PROJECT TITLE: Bugg Property ZONE ATLAS/DRNG. FILE#: J-12-Z D005

RE: DRAINAGE PLAN FOR THE BUGG PROPERTY (J12-D5) ENGINEER'S STAMP
DATED 7/9/97

RE: REVISED DRAINAGE PLAN FOR THE BUGG PROPERTY (J12-D5) REVISION
DATED 8/25/97

Re: DRB#96-402 Bugg Property
WCEA File: 97-210-022

MANHOLE CONNECTION DETAIL

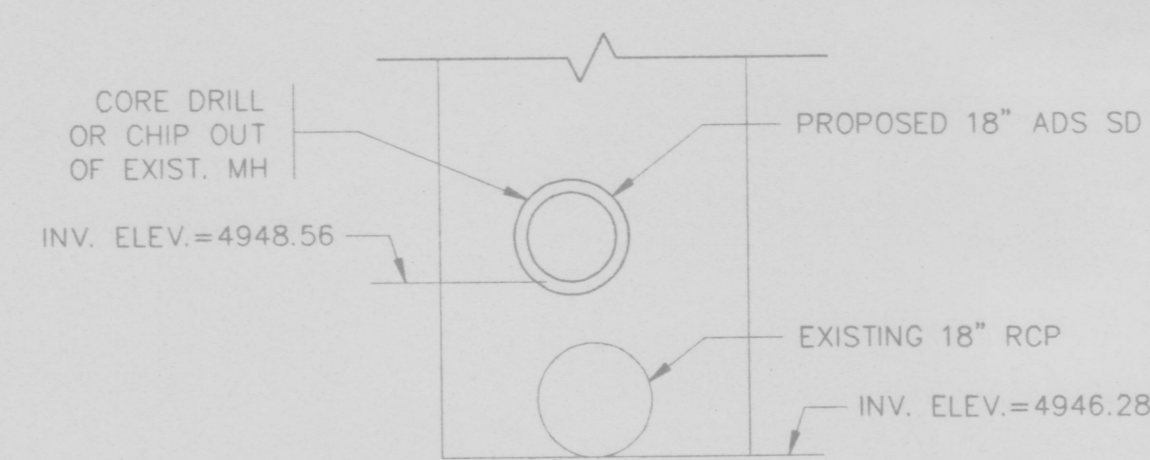
1. Block wall along the North property line to block off the proposed vacated alley.
2. Blanket drainage easement for cross-lot-drainage from lot 11-A on to Lot 12-A shown On the plat.
3. Minor grading within the alley to eliminate ponding against the proposed block wall.
4. More detail on the connection to the existing manhole. Recommend that you check with Glenn Jurgensen from arroyo maintenance for the connection.

The comments concerning the Bugg Property grading and drainage plan have been addressed. A solid block wall along the north property line has been noted on the plan with minor grading away from the wall for drainage. A detail has been provided on the plan for the connection to the existing manhole.
